From: Angus Eitel [REDACTED]
Sent: 13 May 2019 11:59
To: Simon Davis <Simon.Davis@arun.gov.uk>
Subject: Re: BN/12/19/PL The Cottage Piggeries - Changes to Replacement Dwelling.

Proposed Roof Plan

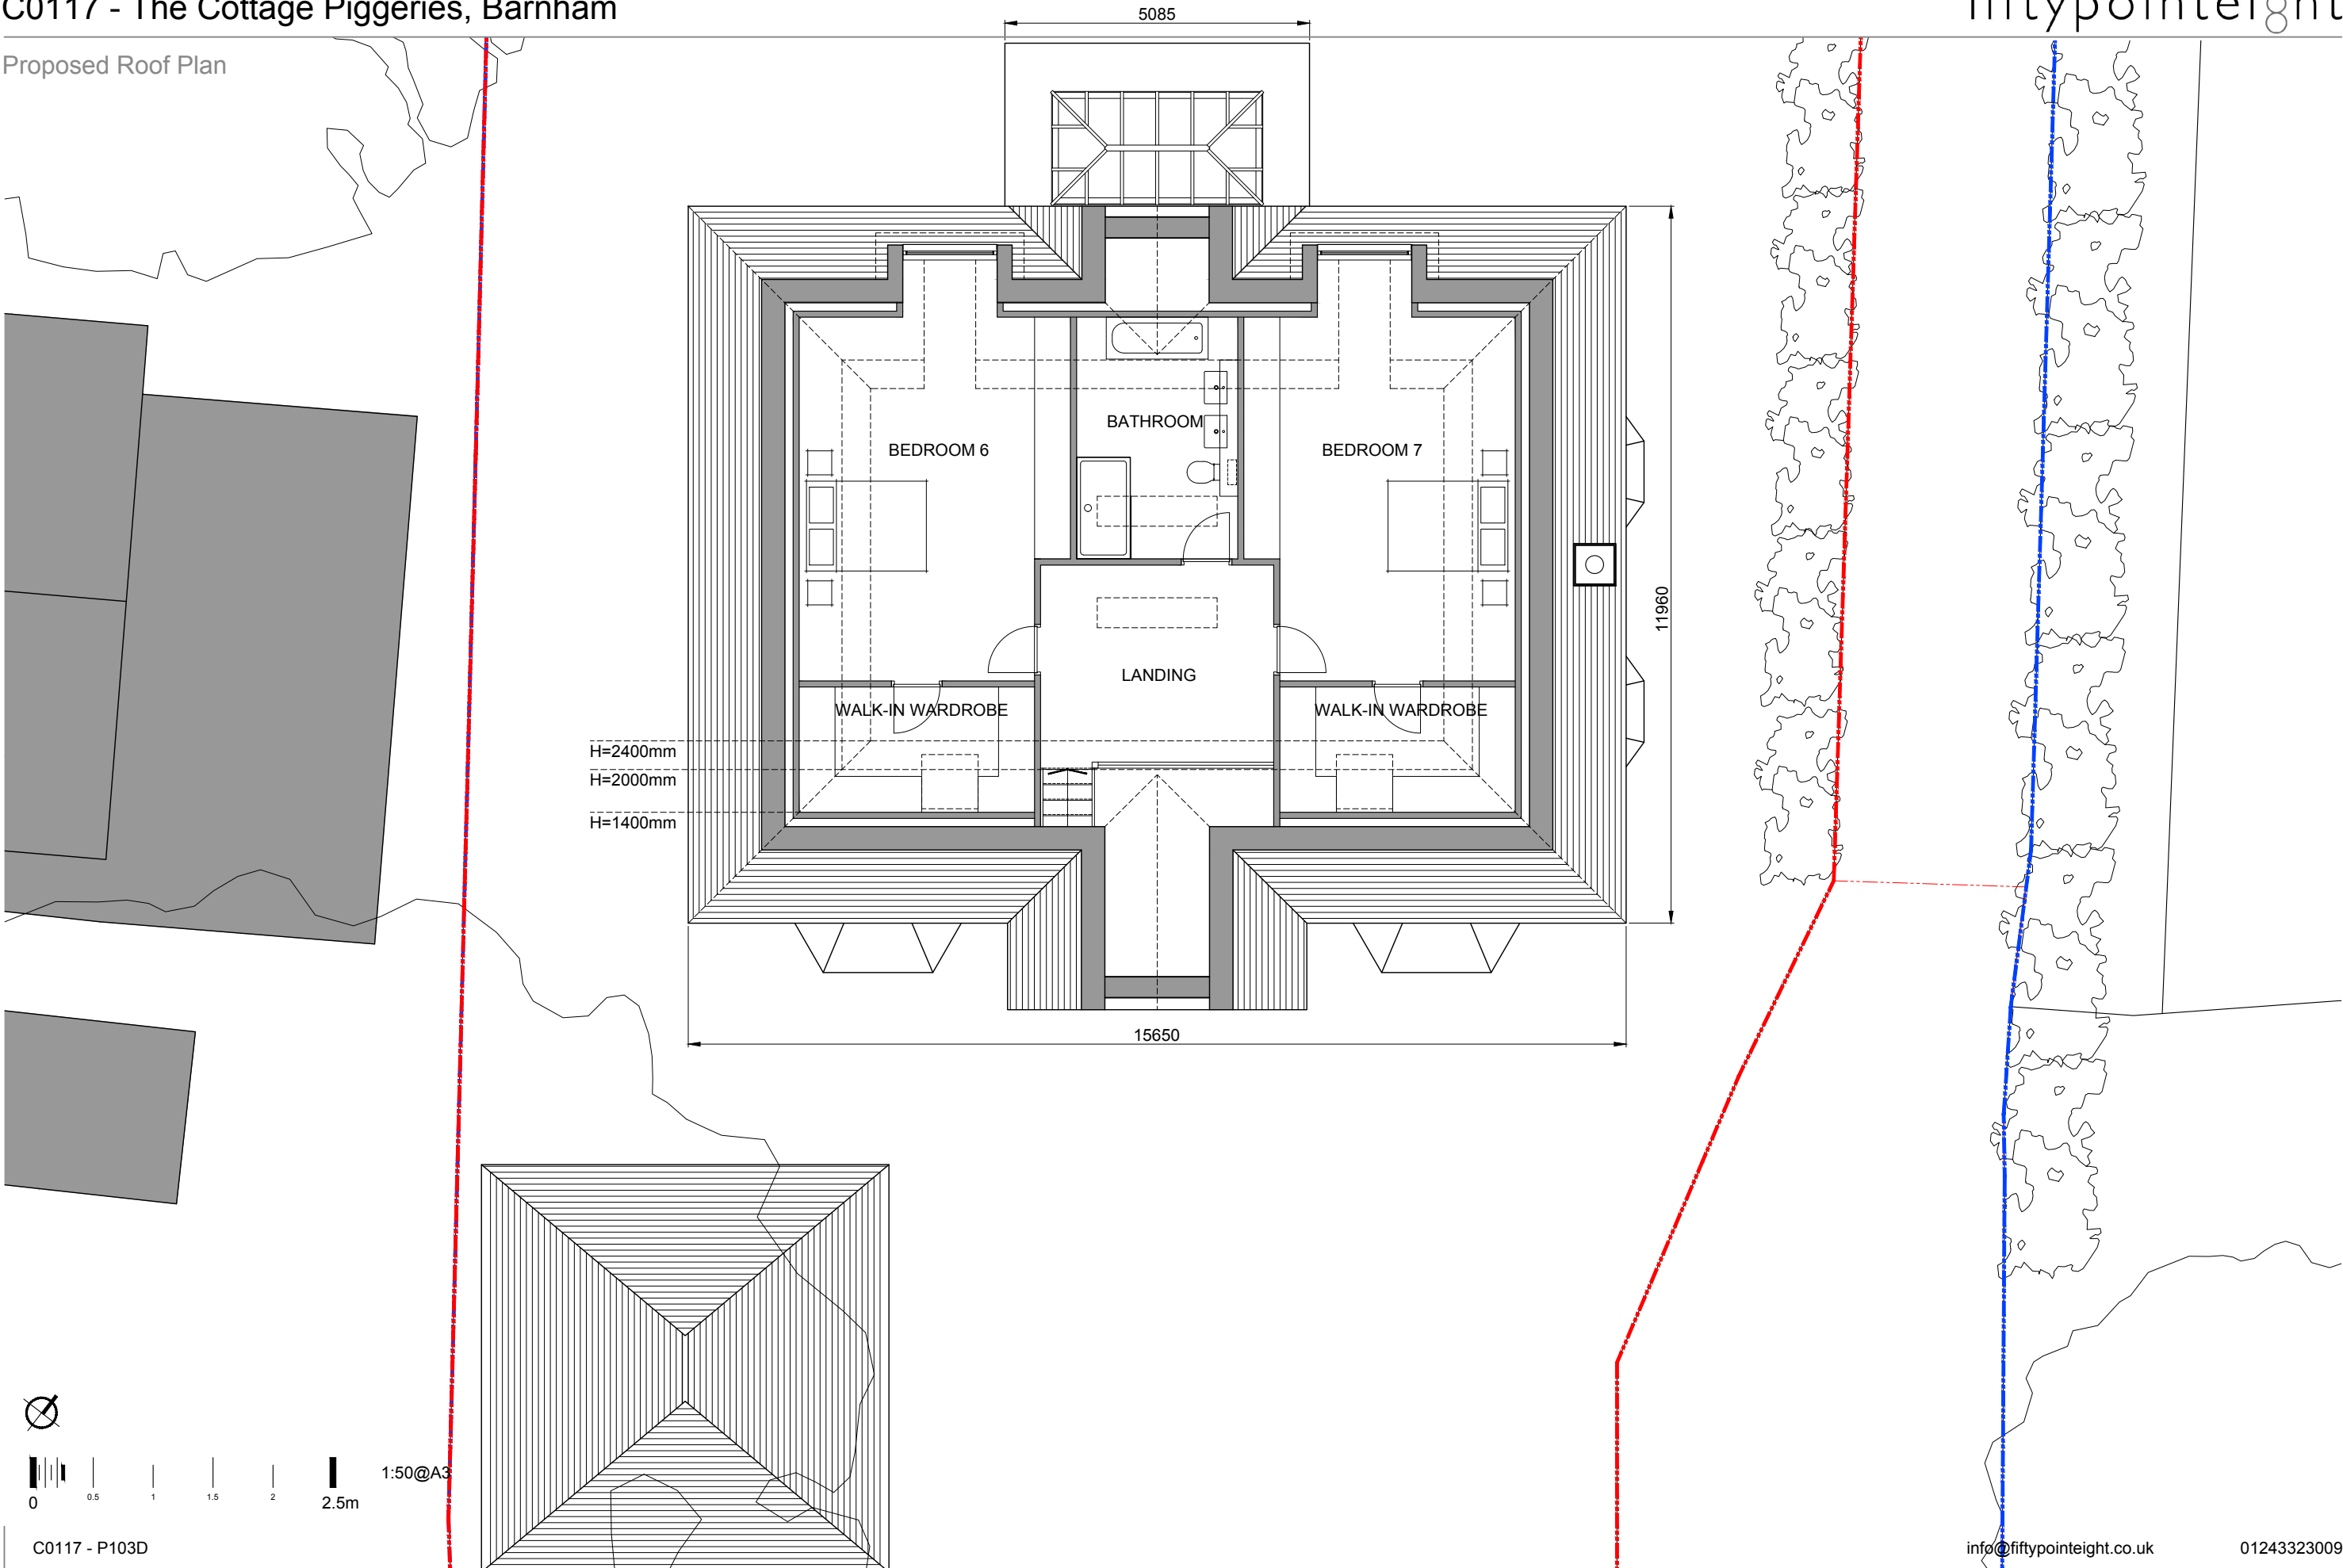
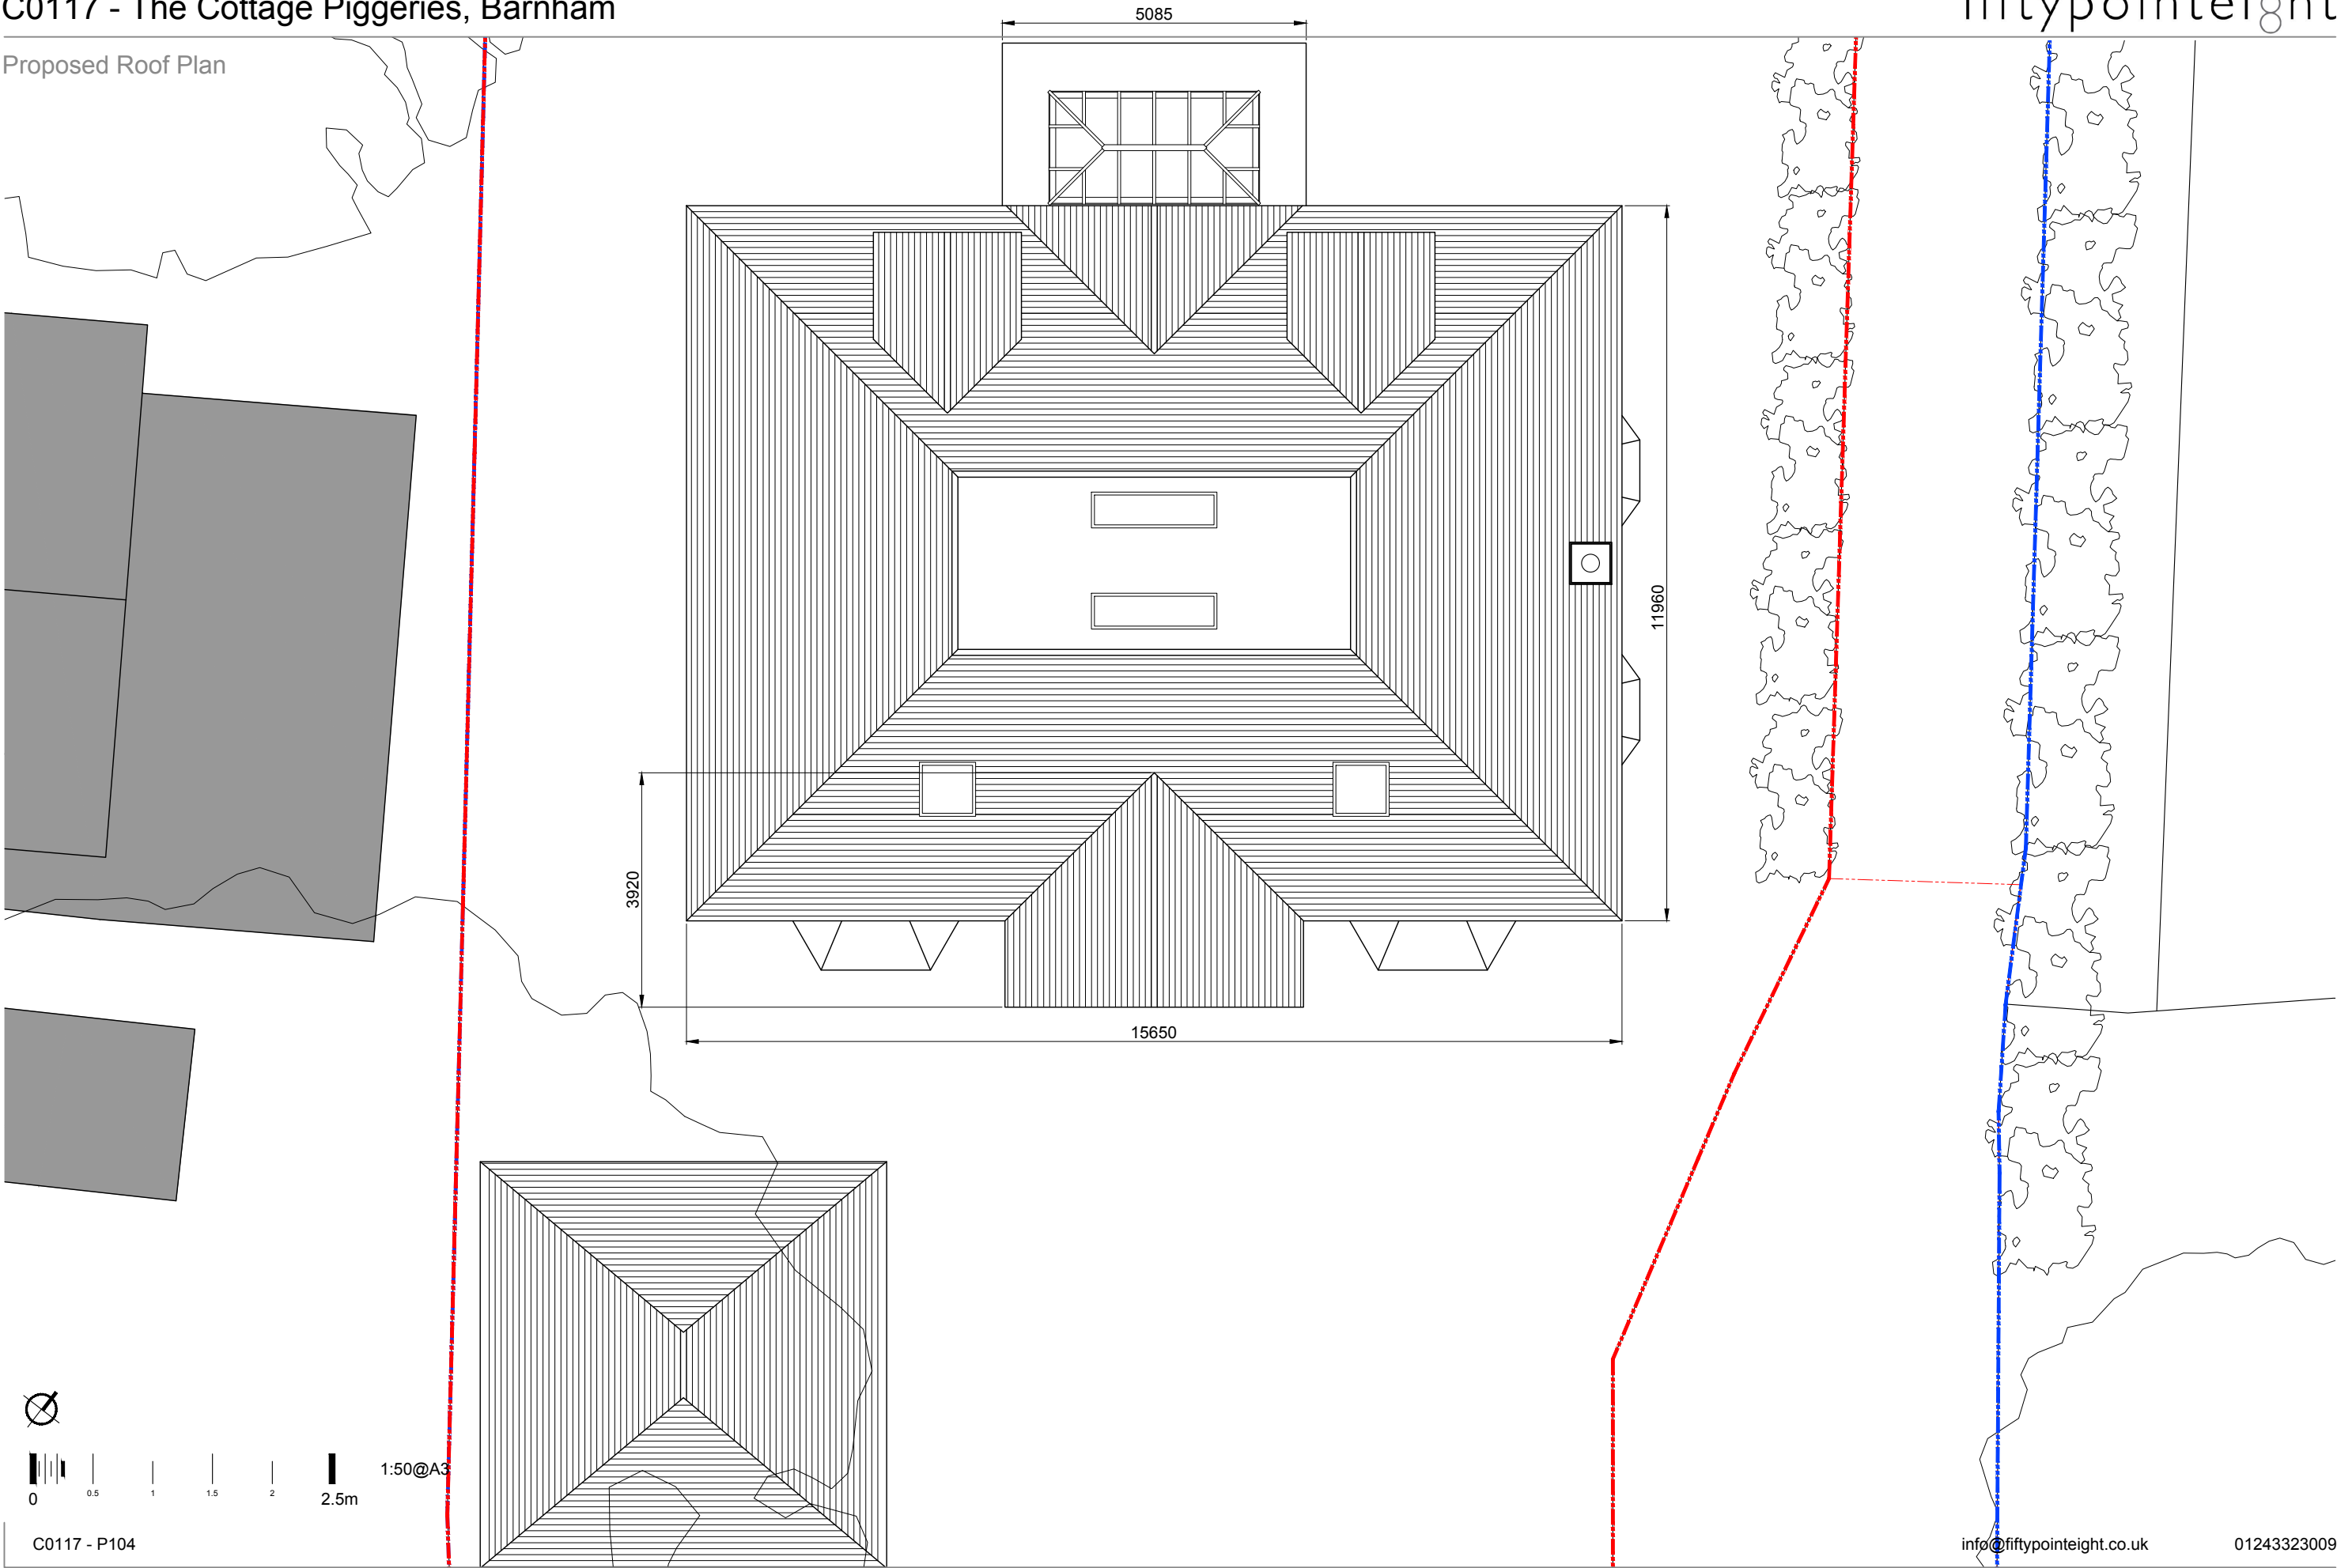
provide me with a cross section of the proposed roof level accommodation so that I can check the heights of the velux windows. Subject to this, we may or may not need to impose an obscure glazing condition on these two velux windows.

Proposed section attached, showing heights at velux positions.

We are comfortable with a condition imposing obscured glazing on the two veluxes.
